# MIDDLETON STONEY ROAD, BICESTER.

## PROPOSED PHASE 1B WORKS

### Stage 1 Road Safety Audit

**SG-AA-2024-4431-RSA1**

REFER TO KEY PLAN FOR EXTRACT LOCATIONS

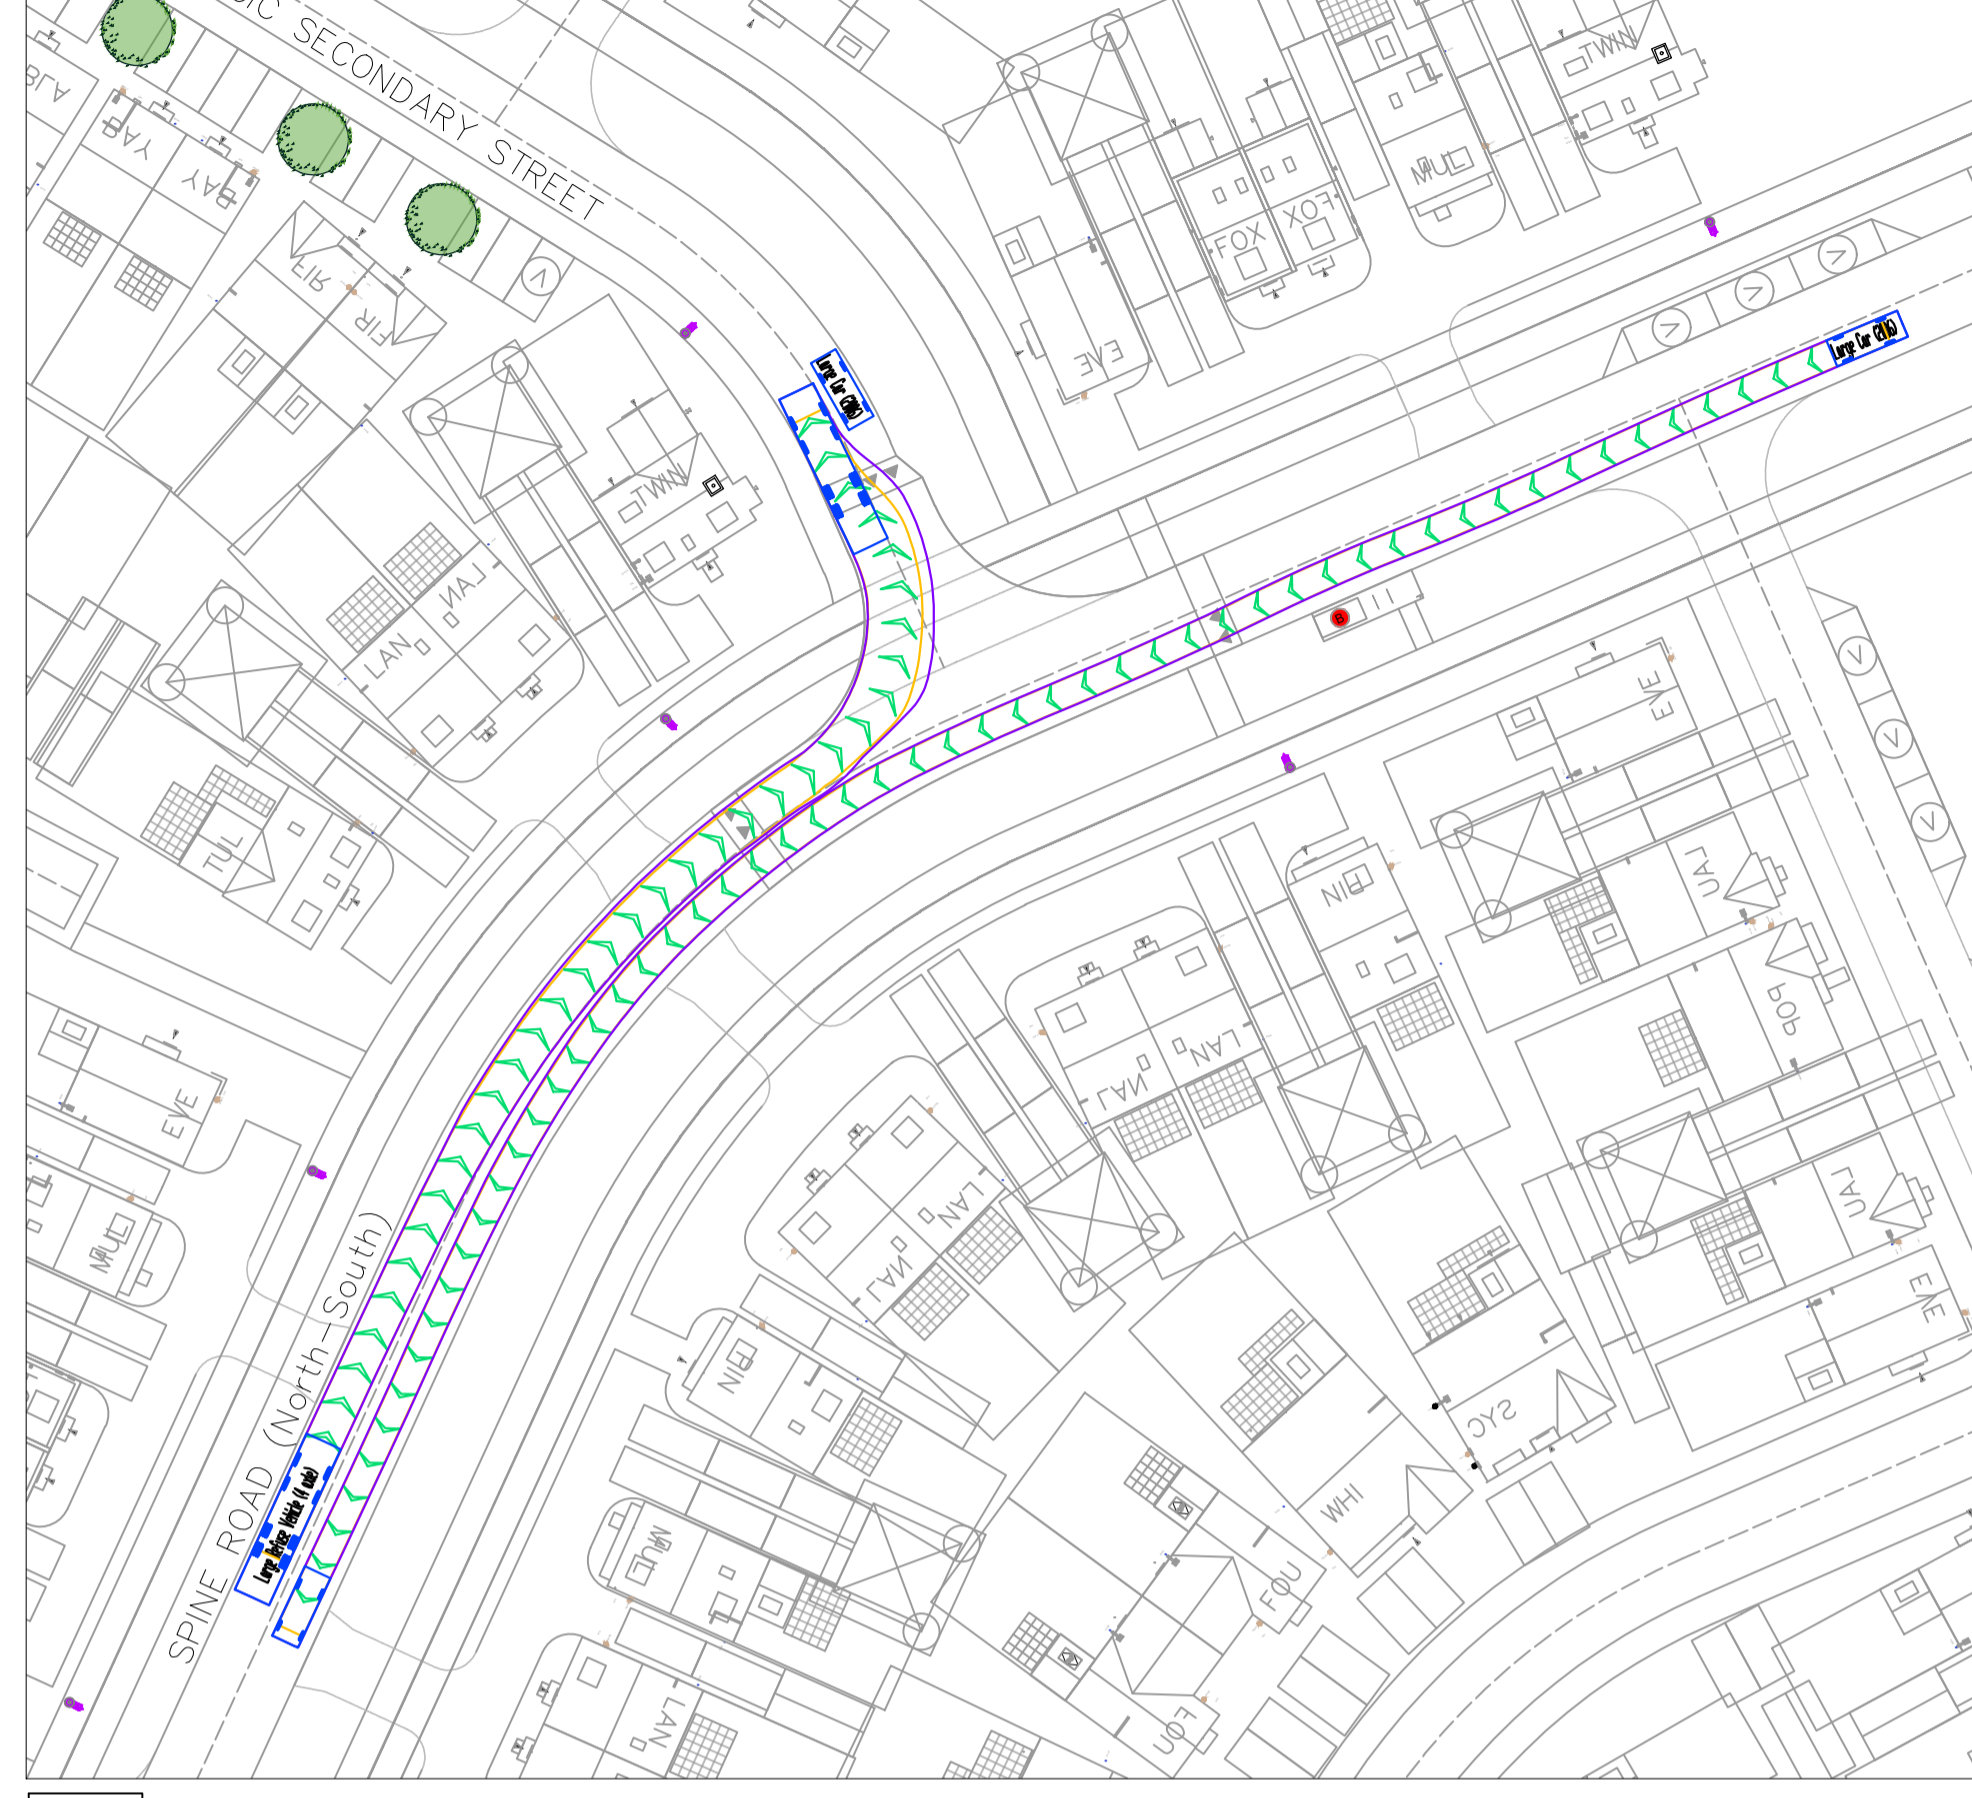
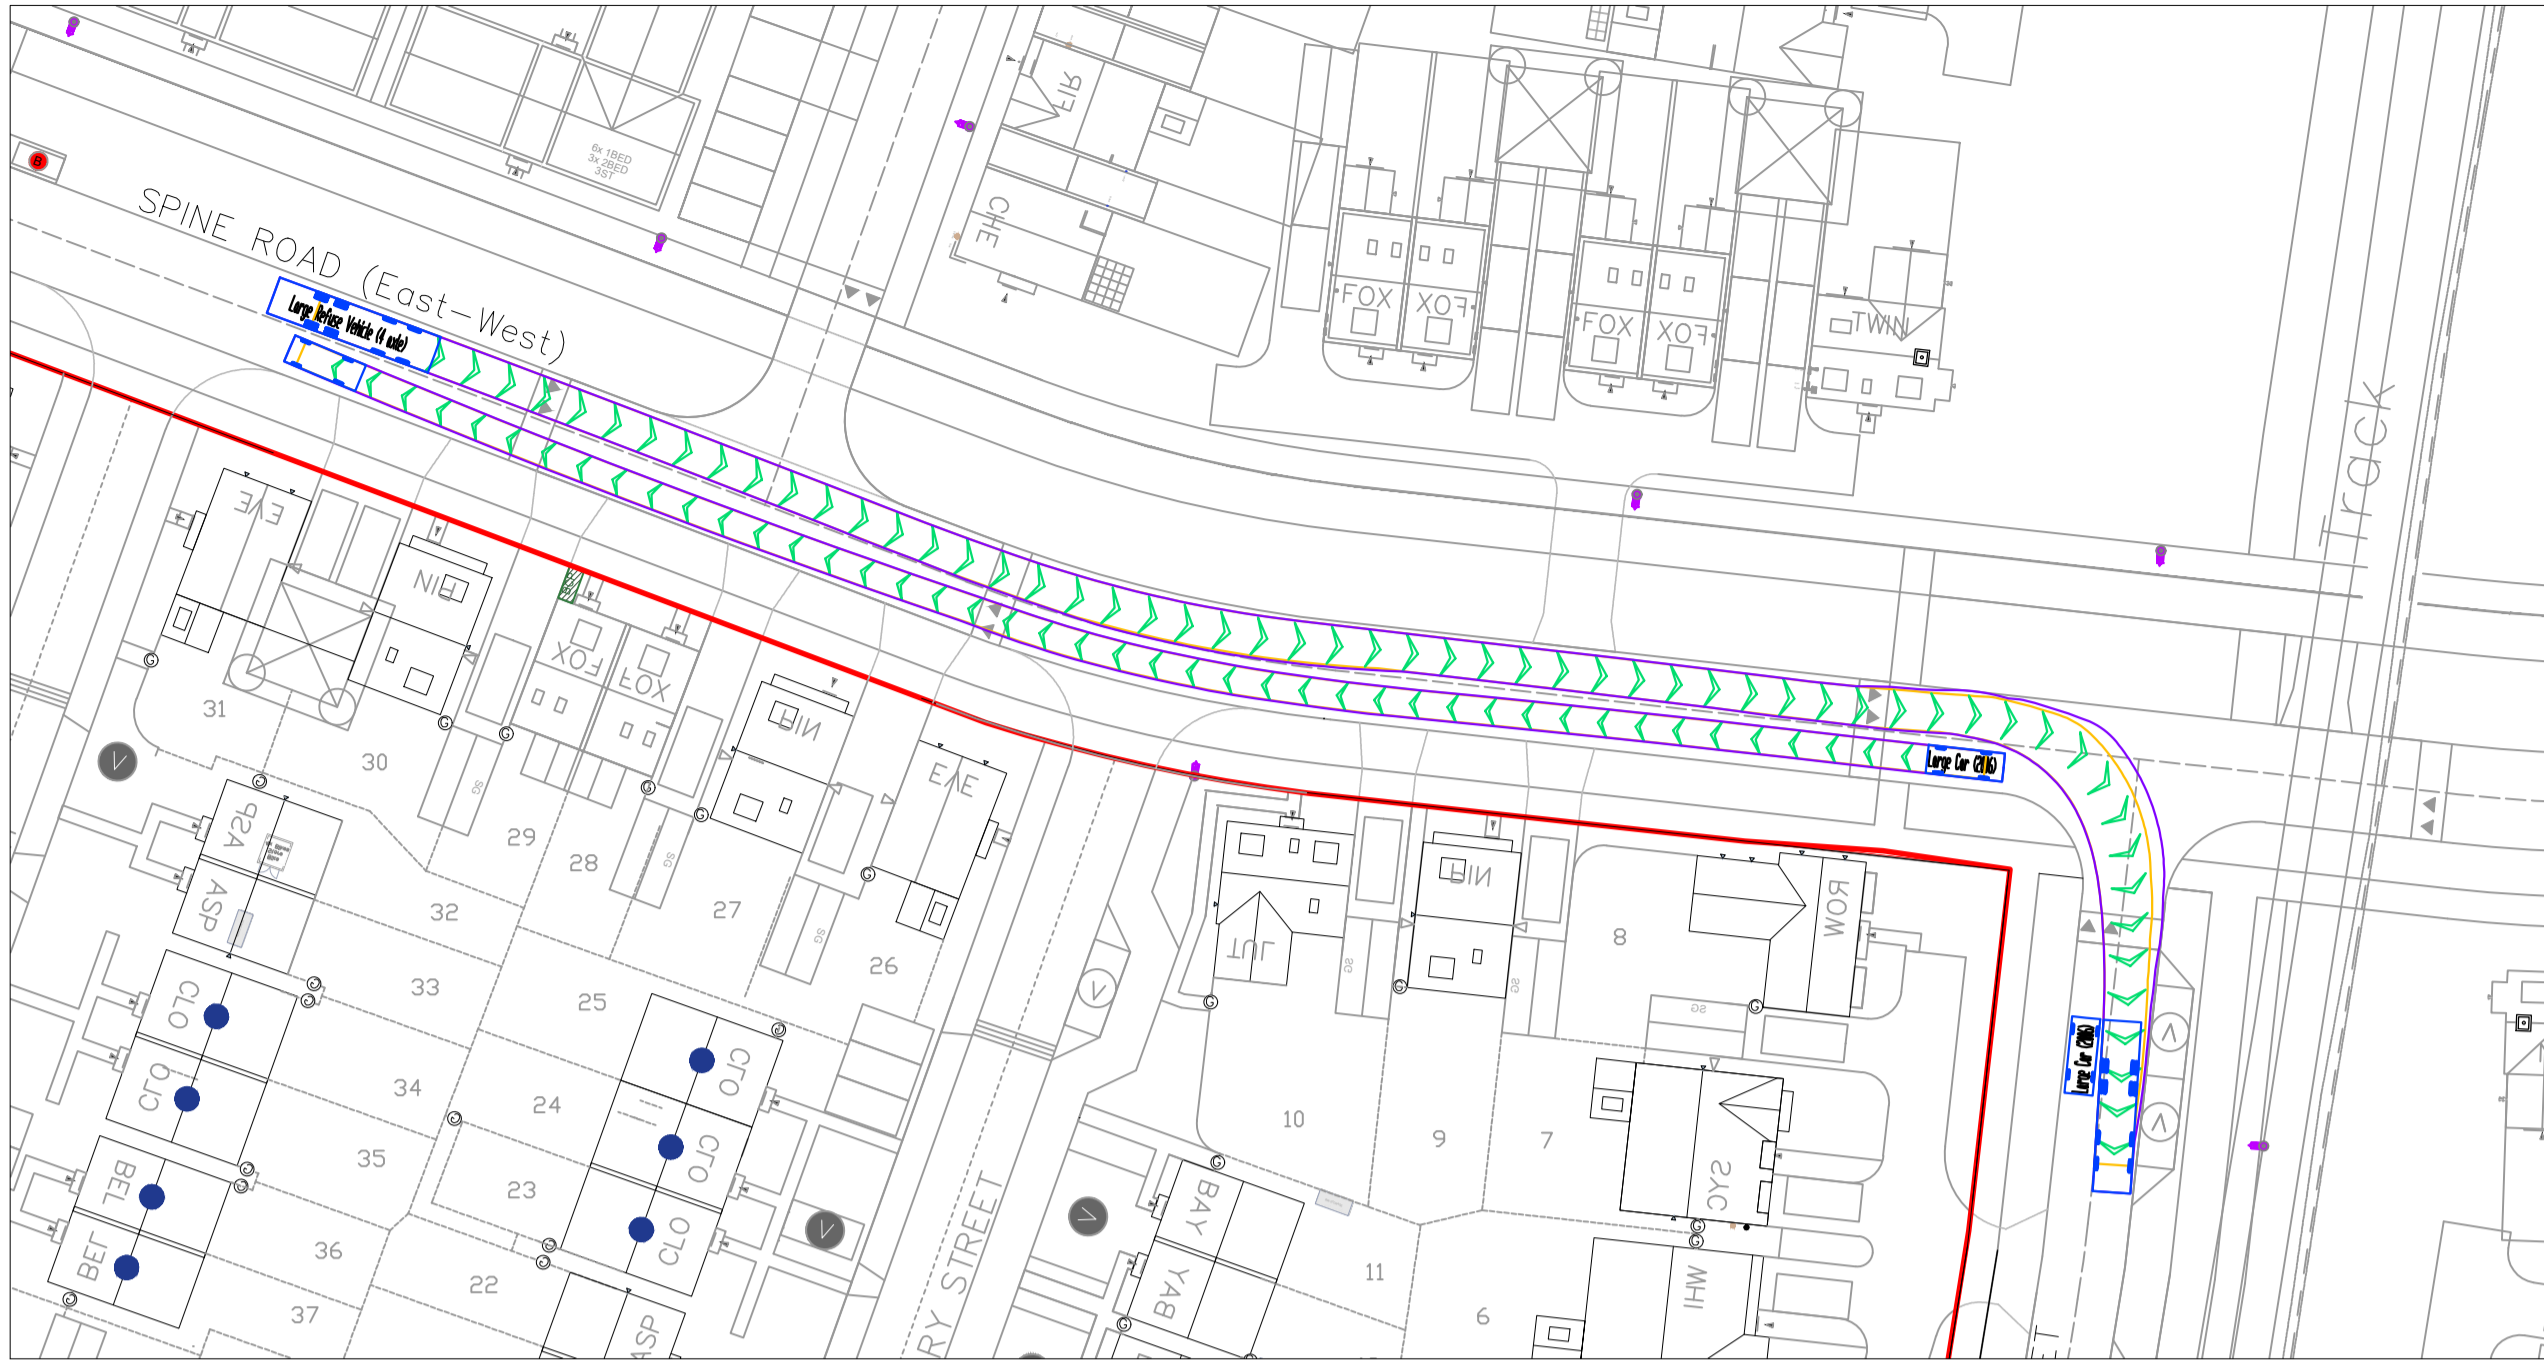
From the vehicle swept path analysis provided as part of the scheme submission, it is evident that larger service/refuse vehicle cannot turn left from the site without encroaching onto the right turn lane. Insufficient carriageway widths to accommodate long wheel based vehicular turning movements may increase the risk of vehicle on vehicle side impact/sideswipe type collisions.

The Audit Team recommends providing adequate carriageway geometry to ensure that all likely vehicle types to use this junction can carry out turning safely and without obstruction.

TITLE
**S278 OFFSITE HIGHWAY WORKS
PRIMARY ACCESS JUNCTION
GENERAL ARRANGEMENT
SHEET 1**

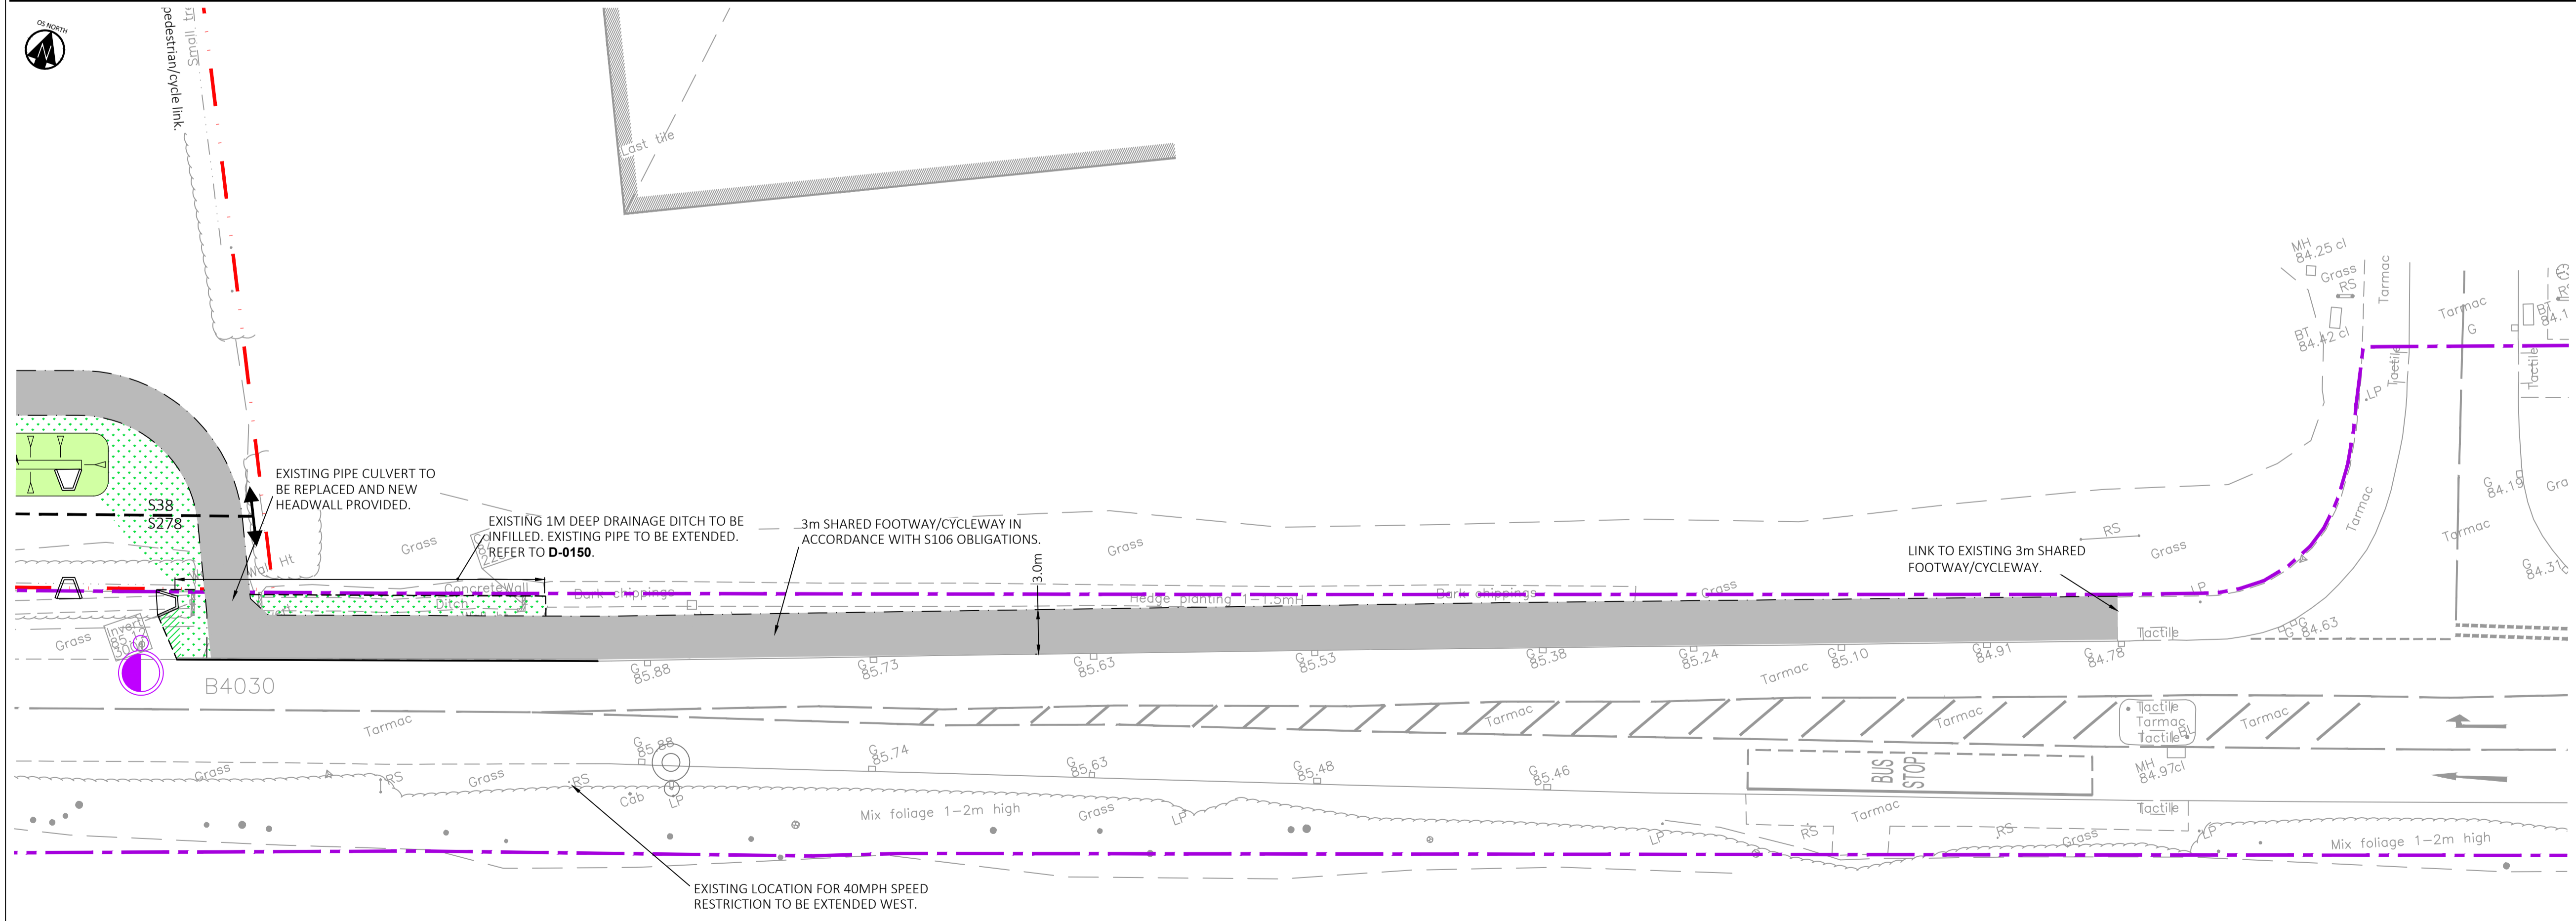
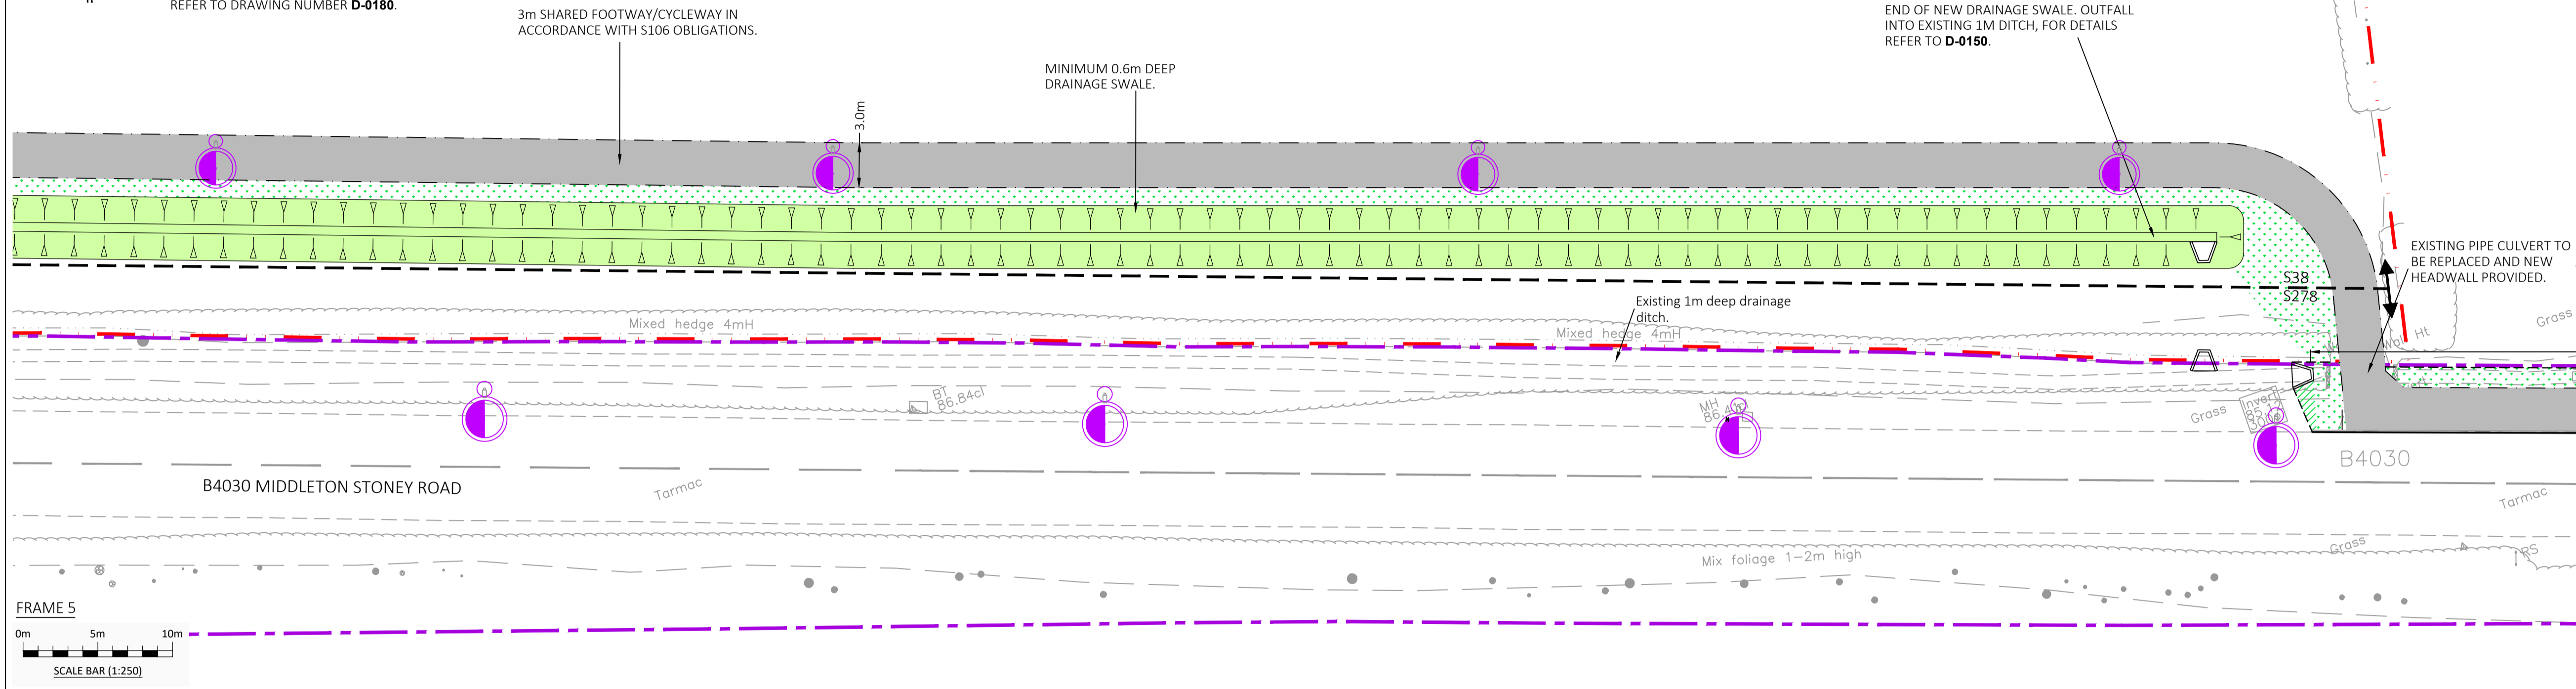
2.5 No deflection arrows have been provided at either end of the proposed ghost island right turn lane. These should be implemented as part of the proposals.

LOCATION: Vehicular access (western end)

SUMMARY: Risk of vehicle to bus type collisions and/or vehicles striking kerb/loss of control

The alignment of the eastbound lane in relation to the proposed bus lay-by is such that it directs road users into the bus lay-by where they may either come into conflict with a bus stopped here or the nearside kerb. This may increase the likelihood of vehicles colliding with busses or single vehicle loss of control collisions as a result of sudden manoeuvring/striking the kerb.

The Audit Team recommends that the eastbound near-side kerb alignment is adjusted to provide a smoother alignment for road users. This could be achieved by providing a more conventional bus lay-by arrangement than that proposed.
